Report to be read in conjunction with the Decision Notice.							
Signed:	Officer:	LE	Date:	8/4/20	Manager:		Date:
Site Notice displayed	N	Photos uploaded	covid	NN 20th April 2020			
Application Ref:	3/2020/00246				 Ribble Valley Borough Council www.ribblevalley.gov.uk		
Date Inspected:	26.2.20						
Officer:	LE						
<b>DELEGATED ITEM FILE REPORT:</b>					<b>Decision</b>	<b>APPROVE</b>	
<b>Development Description:</b>							
<b>Site Address/Location:</b>							
Banks Cottage, Chipping Road, Longridge, PR3 2NB							
<b>CONSULTATIONS:</b>			<b>Parish/Town Council</b>				
TBC No objection							
<b>CONSULTATIONS:</b>			<b>Highways/Water Authority/Other Bodies</b>				
<b>LCC Highways:</b>			No objection				
<b>CONSULTATIONS:</b>			<b>Additional Representations.</b>				
None							
<b>RELEVANT POLICIES AND SITE PLANNING HISTORY:</b>							
<b>Ribble Valley Core Strategy:</b>							
Key Statement DS1 – Development Strategy

The application seeks consent for the construction of a large detached garage / workshop building and alterations to the site access.

PROPOSED GARAGE/ WORKSHOP: FLOOR PLAN & ELEVATIONS

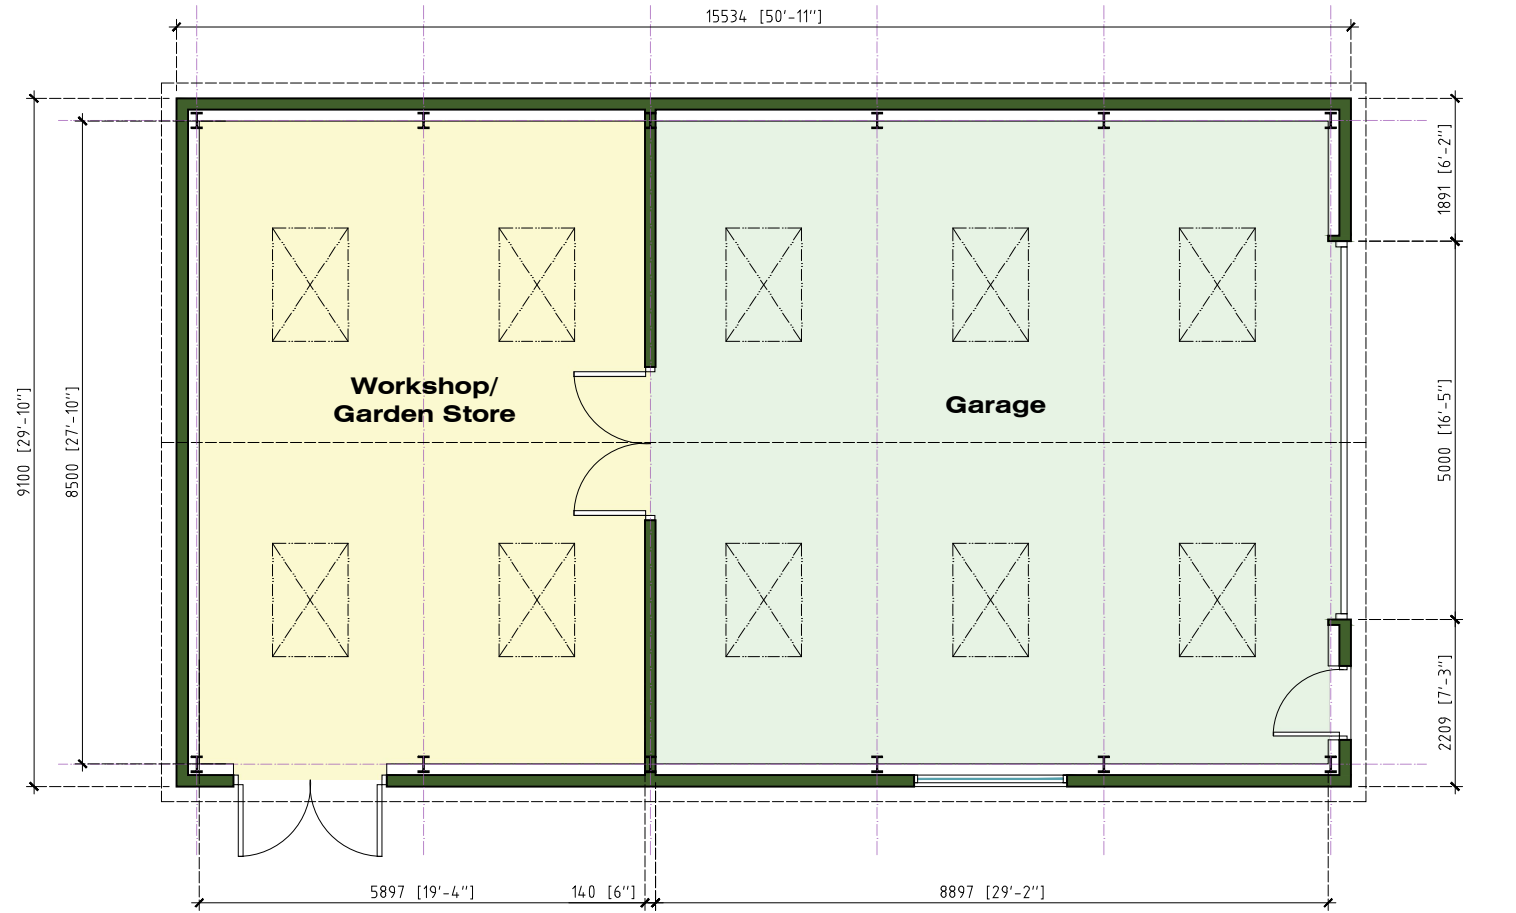
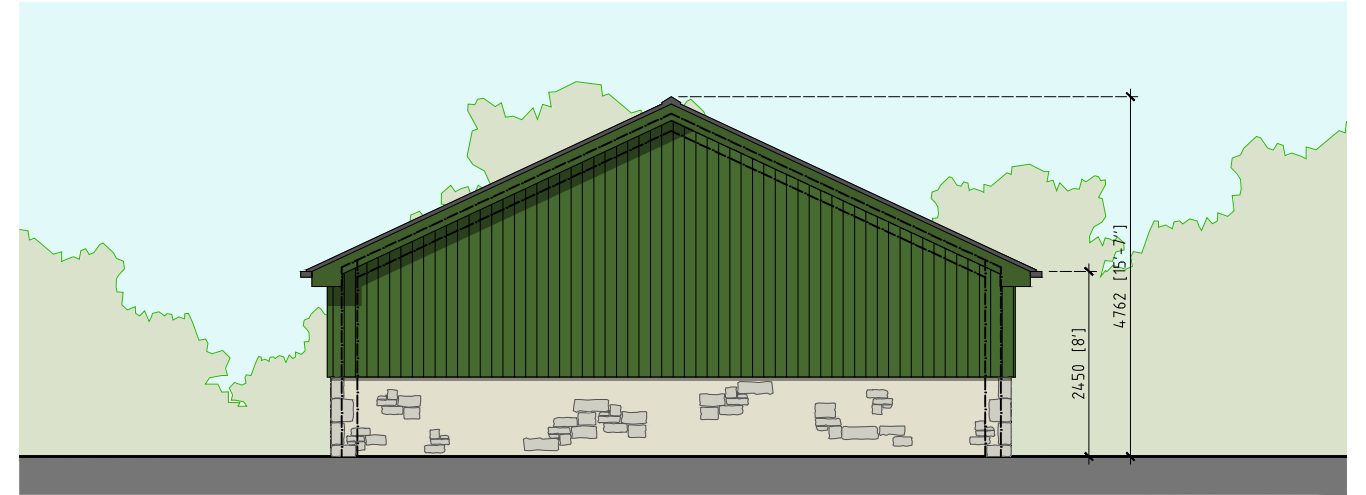
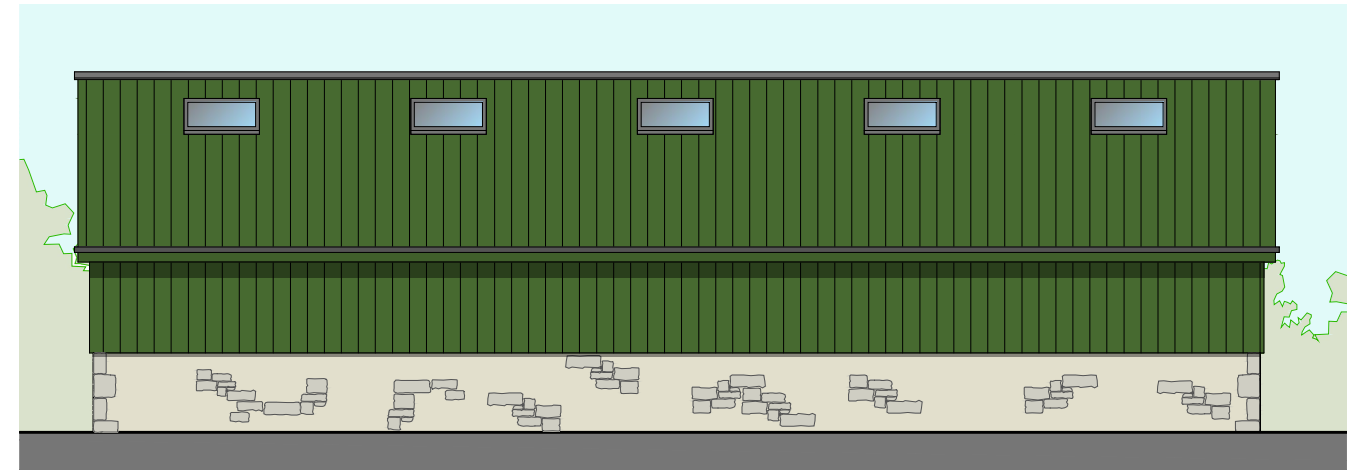
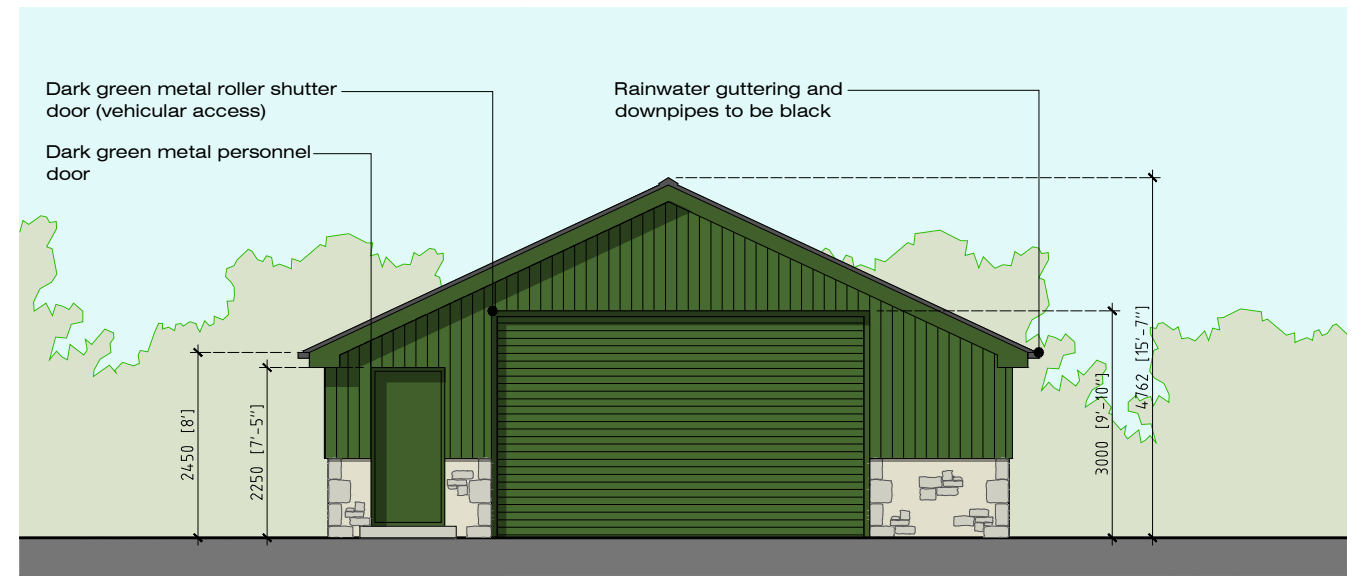
The building will be located to the rear of the house and measures 15.5m x 9m x 4.7m. Approximately 2/3 will be for garaging and 1/3 for a workshop. It will have a stone plinth with corrugated metal sheeting for the rest of the walls and roof and roller shutter door.

The scale and design of the building is more akin to an agricultural storage or industrial building and significantly larger than what would be expected as reasonable garage accommodation for a dwelling. It would be at odds with its domestic setting.

It is considered that it would be overdominant and disproportionate to the existing dwelling and would result in an unacceptable encroachment of built form into this open setting.

Furthermore the choice of materials and design would result in a strident feature in the landscape which would be prominent from outside the site and in long distance views and is not in keeping with the character of the surrounding area.

The proposal would have an unacceptable impact on the visual quality of the area and there is no apparent justification for it, as such it is contrary to core strategy policies DMG1, DME2 and DMH5

PROPOSED SITE PLAN-1

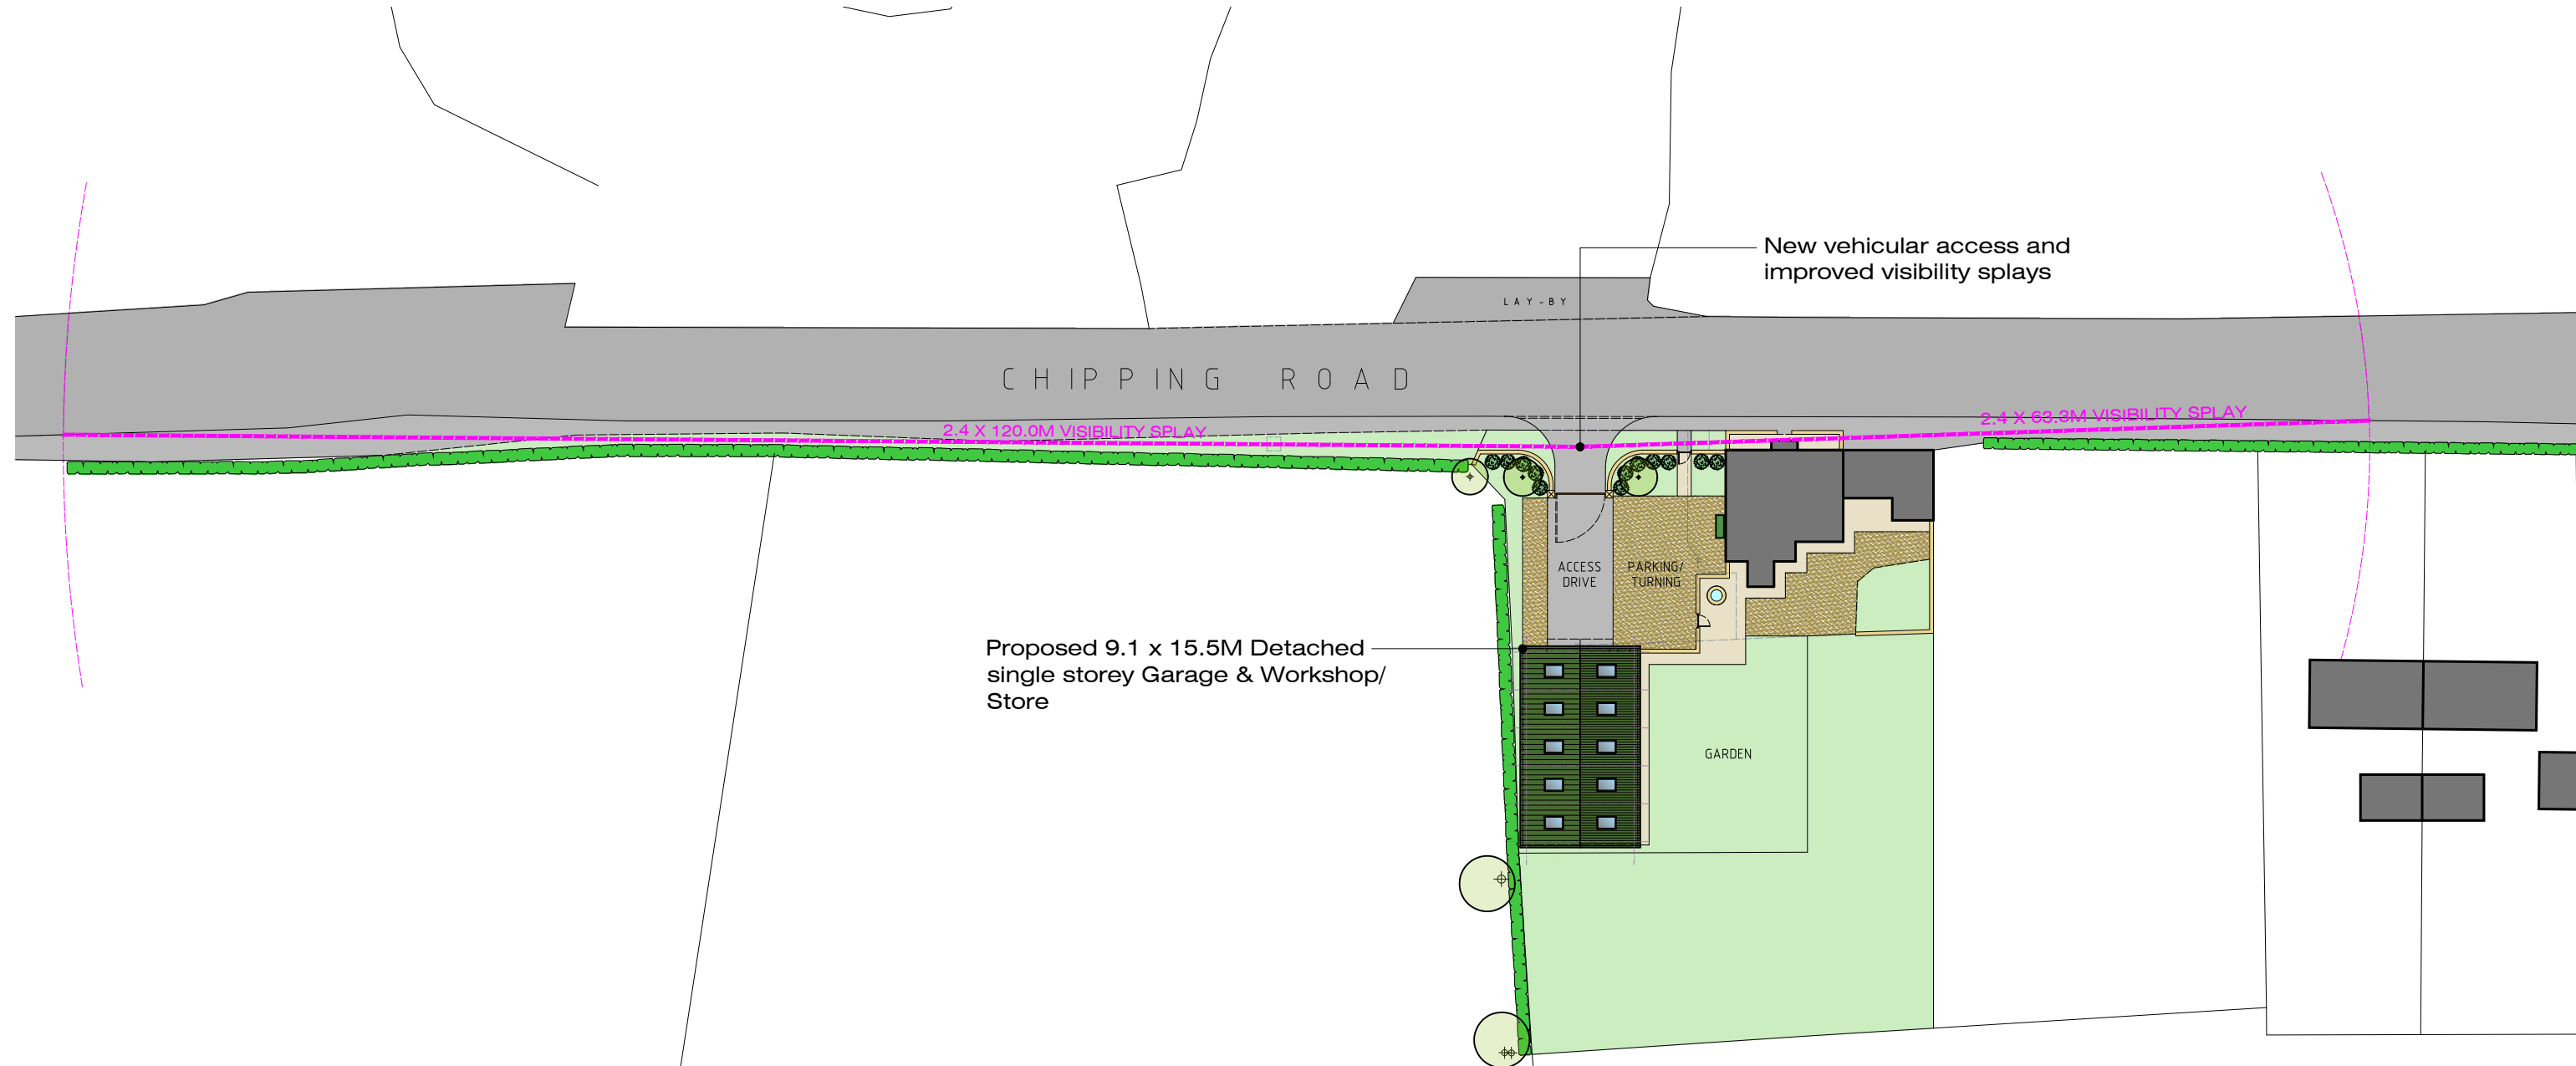
There is an existing vehicular access to the site and this application seeks to alter this access and to improve visibility onto Chipping Road.

The LCC highway officer has said they would not wish to raise an objection to the application. Whilst the improved visibility splays may not be to the required length as would be suggested by the anticipated speed of the passing traffic, they are an improvement on the existing situation. As far as LCC are aware there have been no reported collisions in the area in the last five years. It is assumed, as there is no information to the contrary, that this garage is to be used as a private storage/workshop facility. If this is to be a commercial enterprise then it would not support the access as it is proposed, but look for a further improvement in the visibility splay and the ability to allow two vehicles to pass at the entrance.

Therefore there are no envisaged highway safety implications if the garage is domestic as stated.
